Project: METROLINK	Drawing Title: METROLINK - STRUCTURES NORTHWOOD STATION PROPOSED STREET LEVEL DESIGN	Drawing Status: S0
Drawing N°: ML1-JAI-SRD-MS07_XX-DR-Y-02032	Plan Drawing N°: ML-ST 303 L-M1	
Scales Original Size A1: 1:250	Sheet: 1 of 7

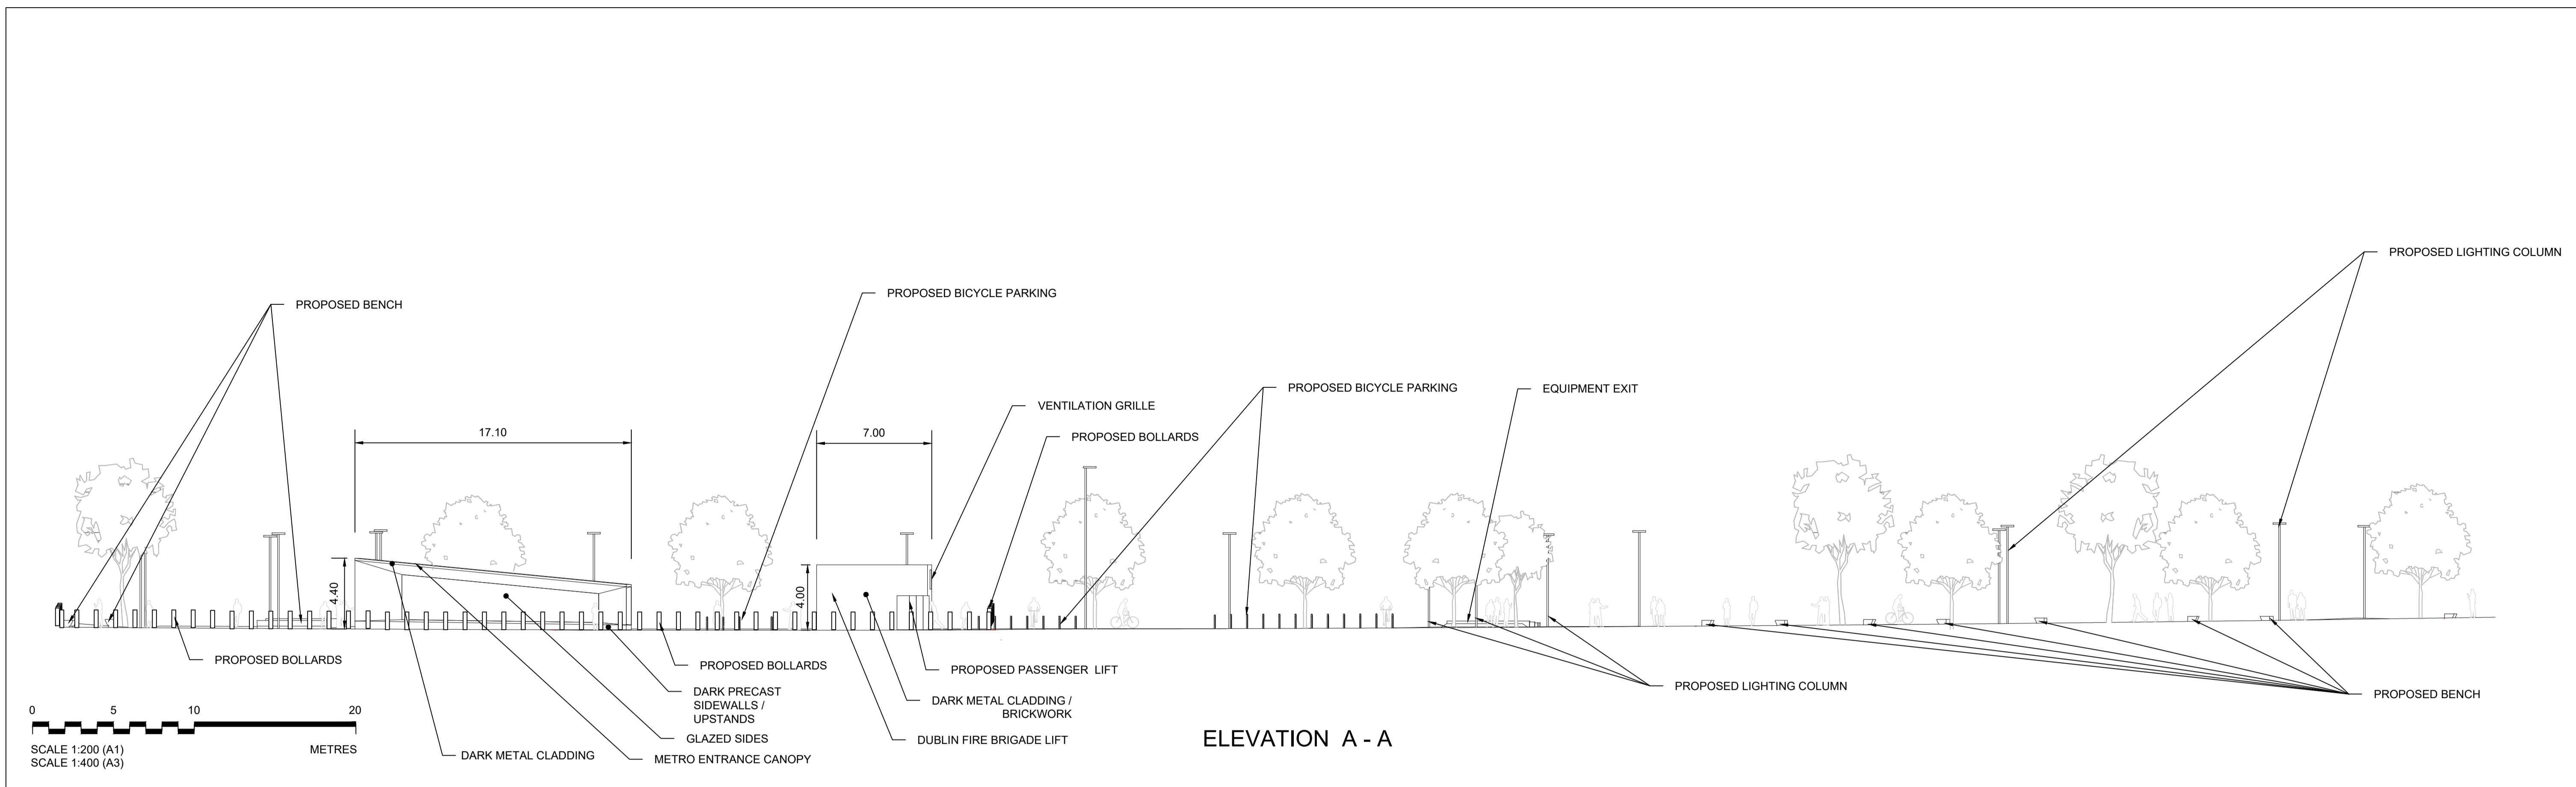
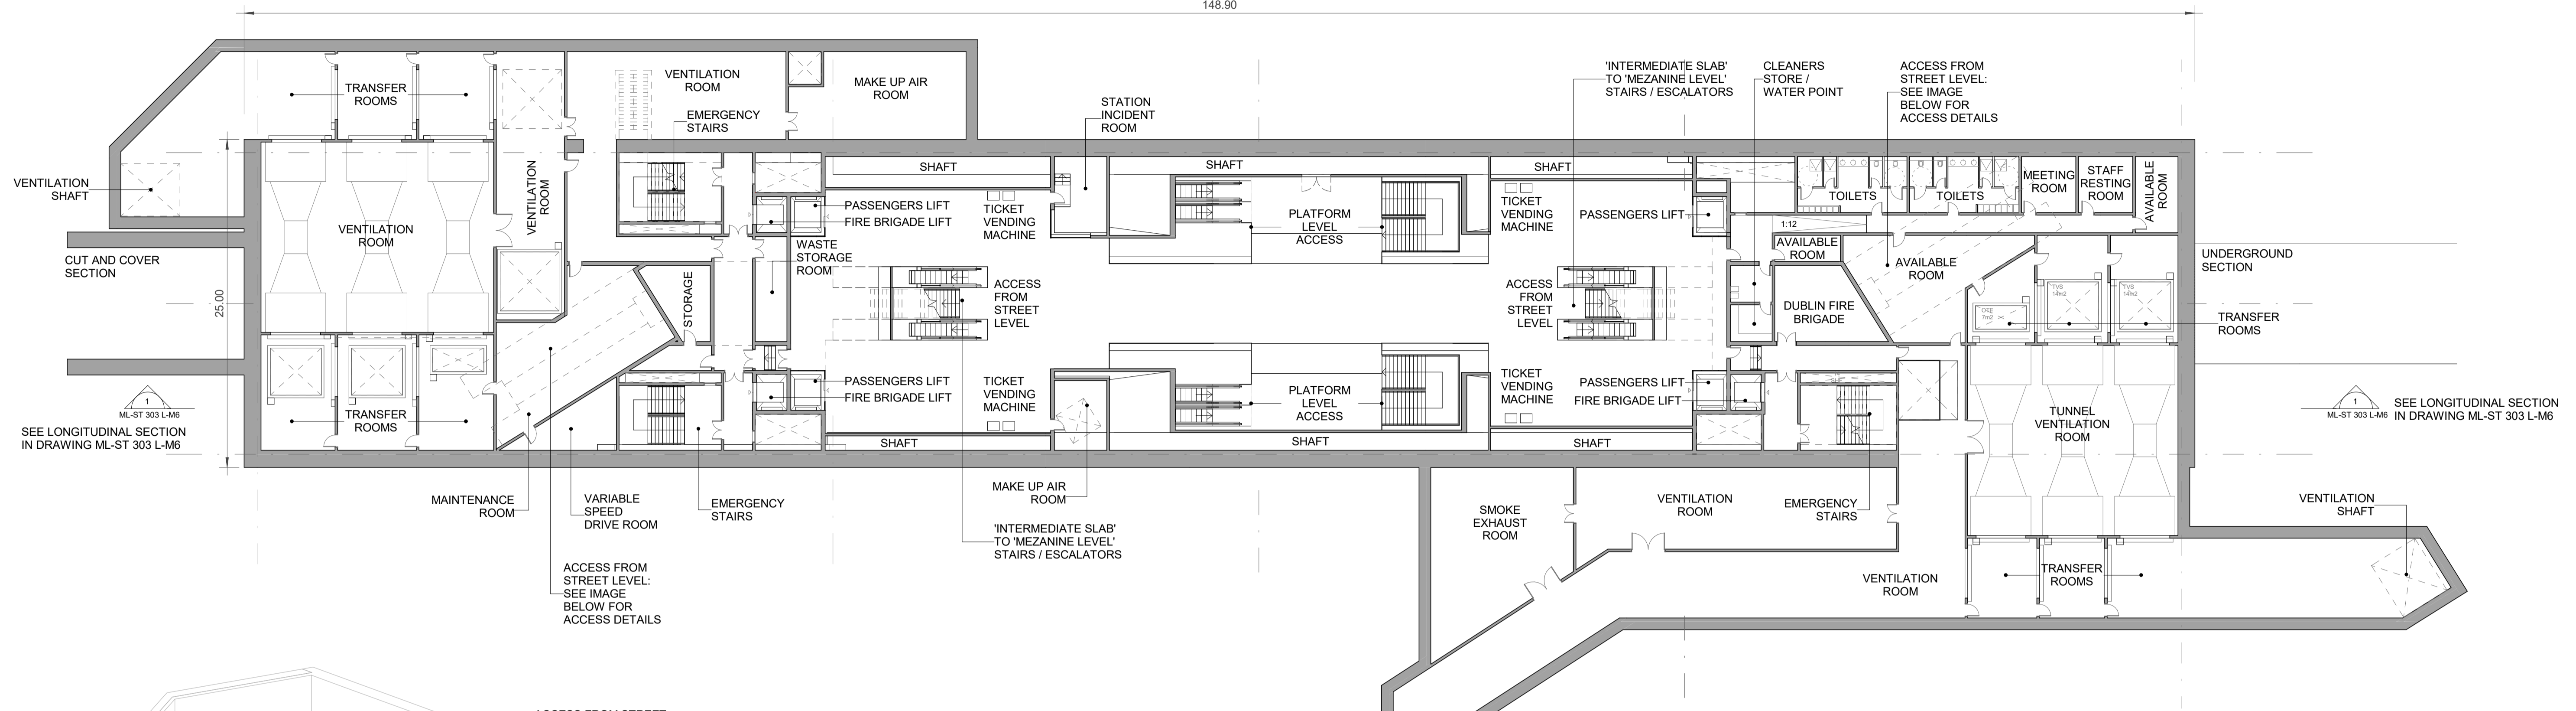
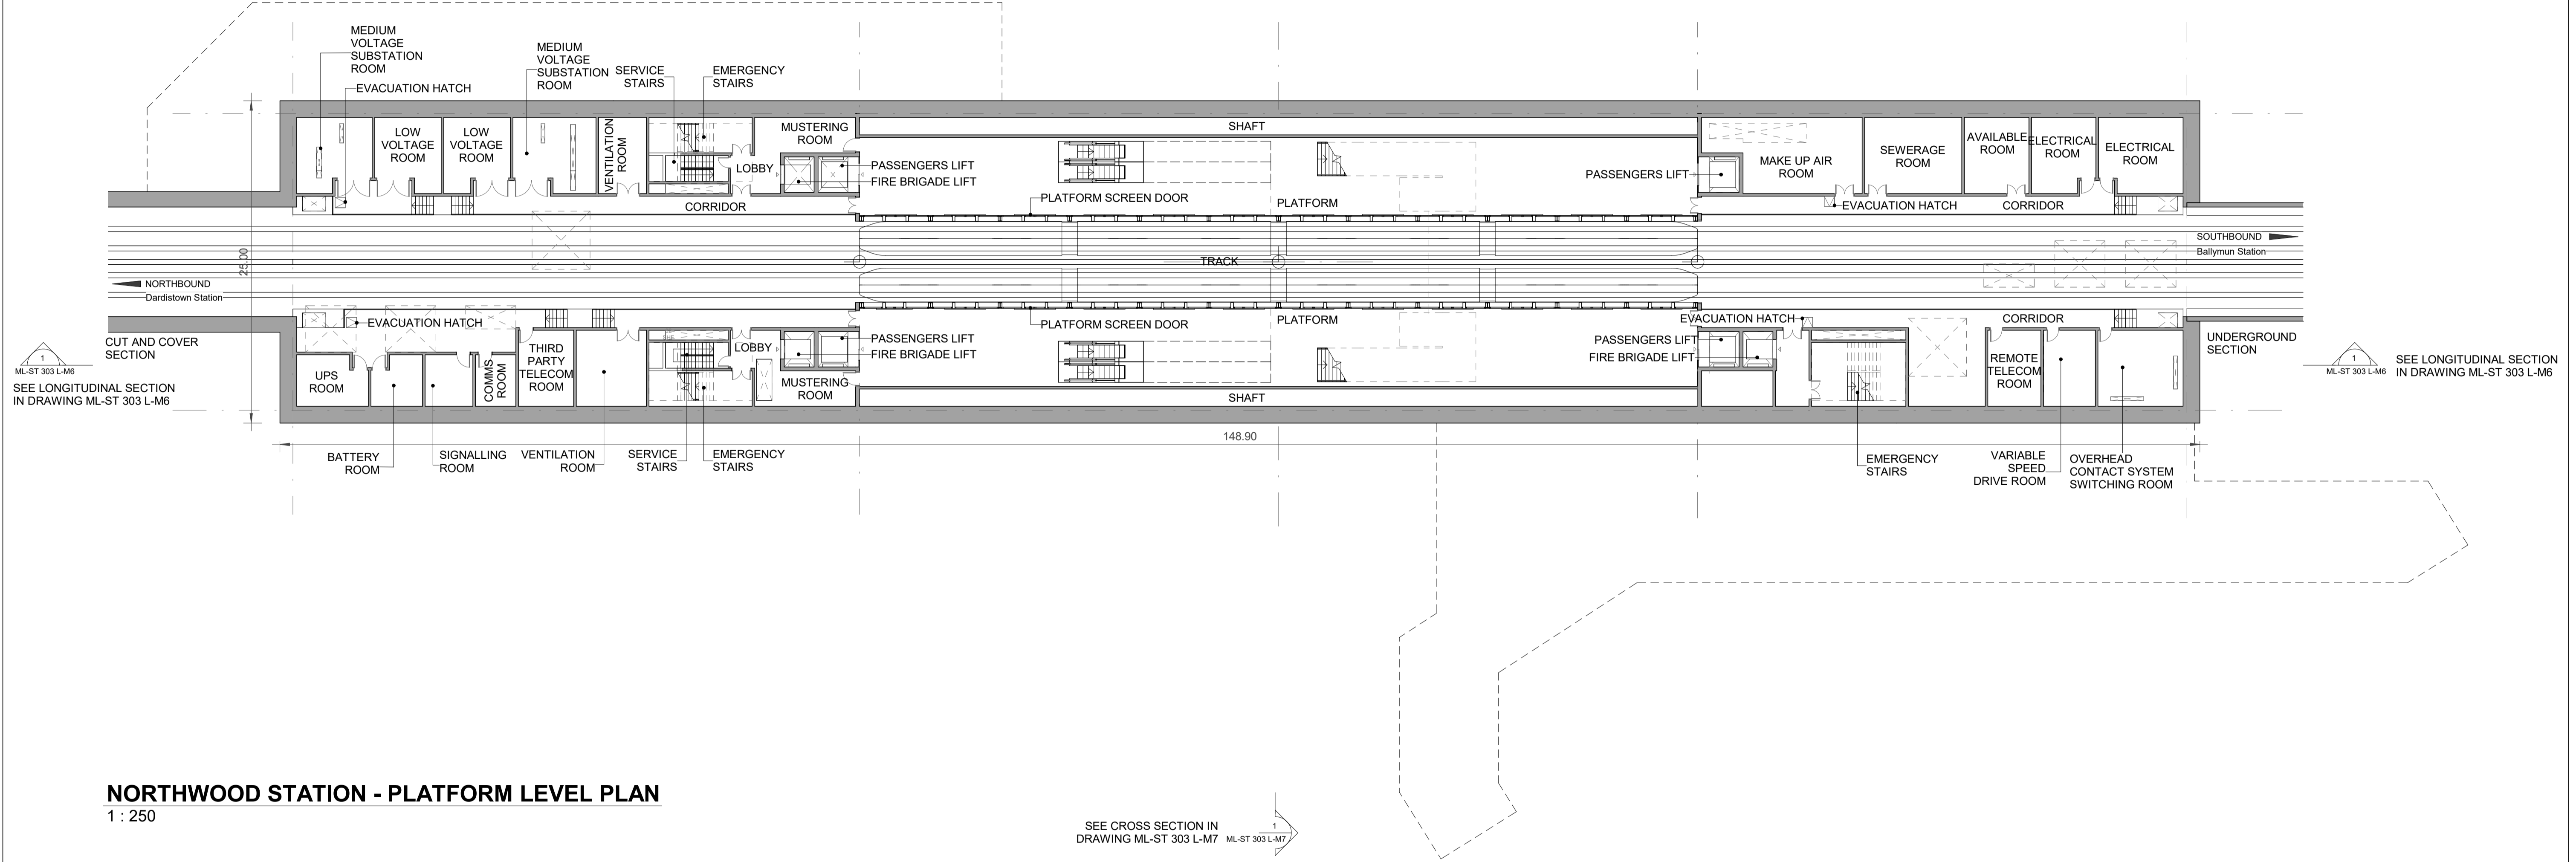
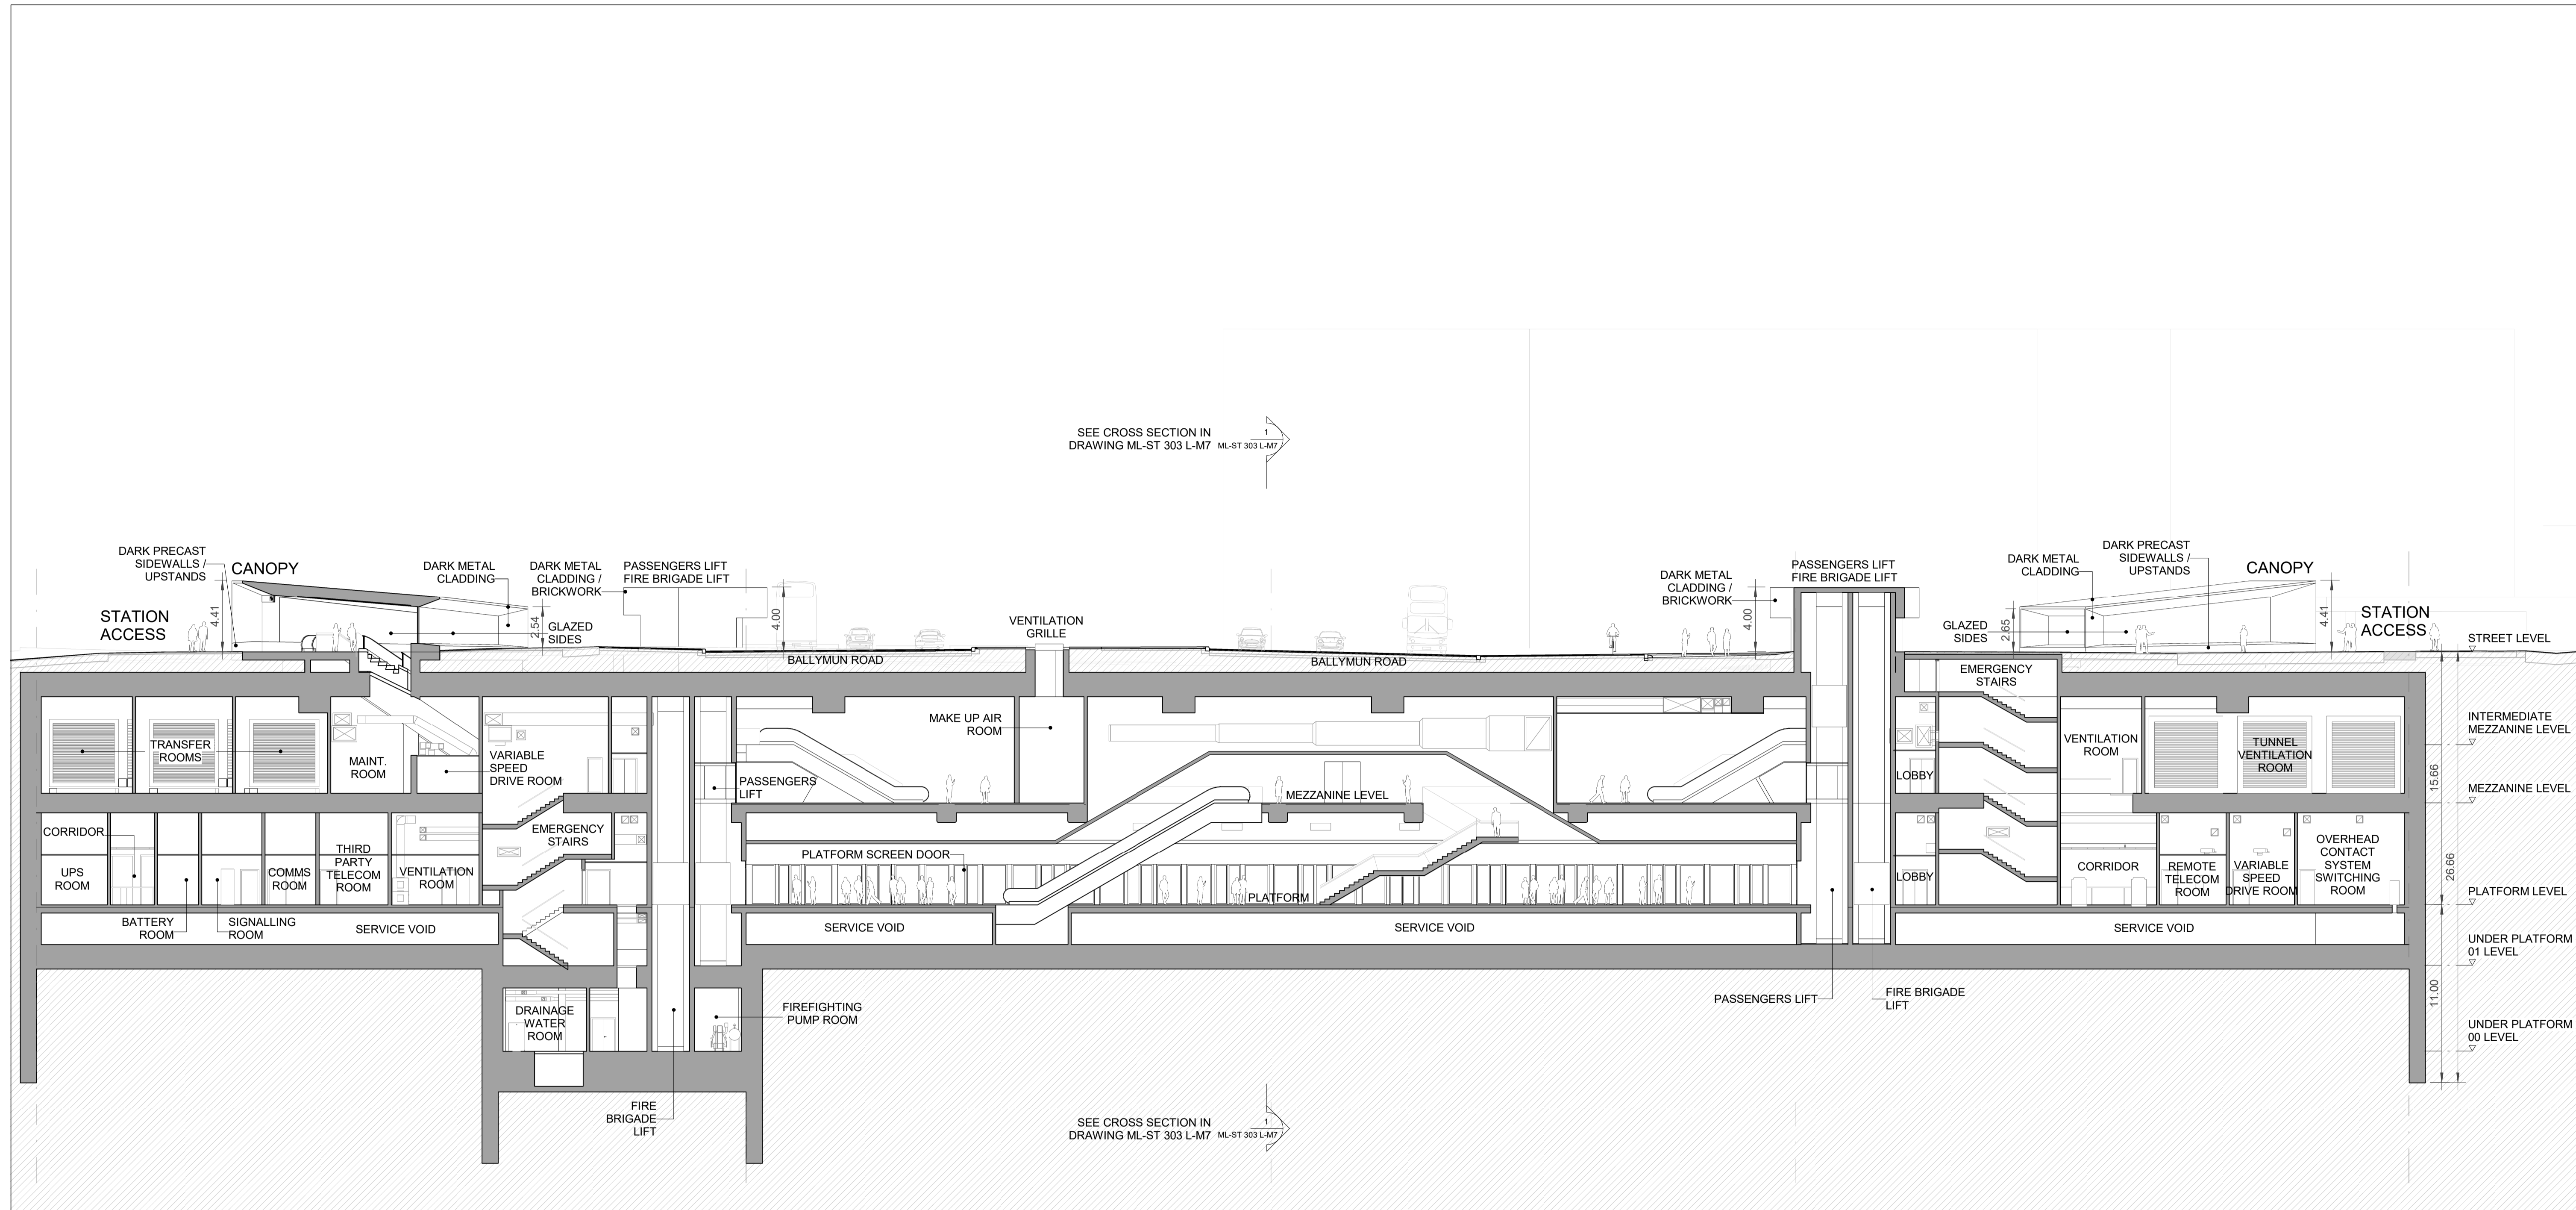
6	<i>Our client would wish to maximise the usable area of their site and would ask that the proposed Northwood station design/ layout be reconsidered to ensure it does not restrict development of the areas to be handed back and that over station development be considered further on the subject site.</i>	<i>Please refer to response item number (1) above.</i>	PUNCH Response: As 1 above.
7	<p><i>As part of a potential future mixed-use development of the subject site, our client, would look to provide a discount Food store on the site.</i></p> <p><i>The MetroLink proposals indicate two areas for potential development adjacent to the proposed station but other sections, such as the northern portion of the site (which the track alignment passes through) do not indicate potential for future development. Vehicle access and car parking provision is an important consideration for a discount Food store (in conjunction with sustainable modes of travel). Vehicle access to the site would likely have to be taken from the Old Ballymun Road positioned towards the northern end of the site (as proposed in the 2013 planning application, see Figure 2), given the layout of the surrounding road network. In turn, this</i></p>	<p><i>MetroLink public realm has been designed in consultation with Lidl by taking Lidl's future development plans into consideration. As discussed in several consultation meetings, the proposed Northwood Station construction works will require the acquisition of the entire site on a temporary basis and the acquisition of the western part on a permanent basis as shown on the RO property plans.</i></p> <p><i>Upon completion of the MetroLink construction works, the retained lands in consultation with TII, can accommodate development in line with zoning objectives, proposed development plans. However, design for any future building or structure immediately adjacent to MetroLink station and tunnel must take cognisance of the MetroLink structures and avoid impact, with the intention of preserving and optimising the scale and value of the Adjacent Site Development recognising that the operational requirements of the station are the overarching priority.</i></p>	Punch Response: As 1 Above

would predetermine access requirements for the car parking layout (both at surface and underground level) and the location of the loading servicing/ delivery facilities for a potential discount food store. As such, ABP in their consideration of the MetroLink proposals should seek to enable a larger area of the subject site be utilised for future development, allowing for the provision for a high-density mixed-use development.		
8	The MetroLink proposal indicates access to the station is to be facilitated by two main entrance points, one on either side of the Ballymun Road, as well as separate emergency access points. It is unclear from the proposal drawing if there are other access requirements to the station or track which our client would have to consider when planning future development. As such, further consideration should be given by ABP at this planning stage, and if necessary, consultation undertaken with our client.	There are two main pedestrian entrances to the station. There are additionally lift locations either side of Ballymun Road each comprising 2 lifts with one for Dublin Fire Brigade. There are additionally surface penetrations for, inter alia, smoke, ventilation and draught relief. TII will require maintenance access to these locations. With regard to development adjacent to the station please refer to Item number (1) above.	MCA Response: Proposed scheme does not overlap with pedestrian entrances or lift locations, based on the metro background information provided to Lidl to date. Any metro services penetrations that may coincide with the proposed scheme are proposed to be engineered so as to allow access for TII where required. It is assumed that a plenum zone below the Lidl store (between the Lidl store and metro station) will allow this measure of flexibility.
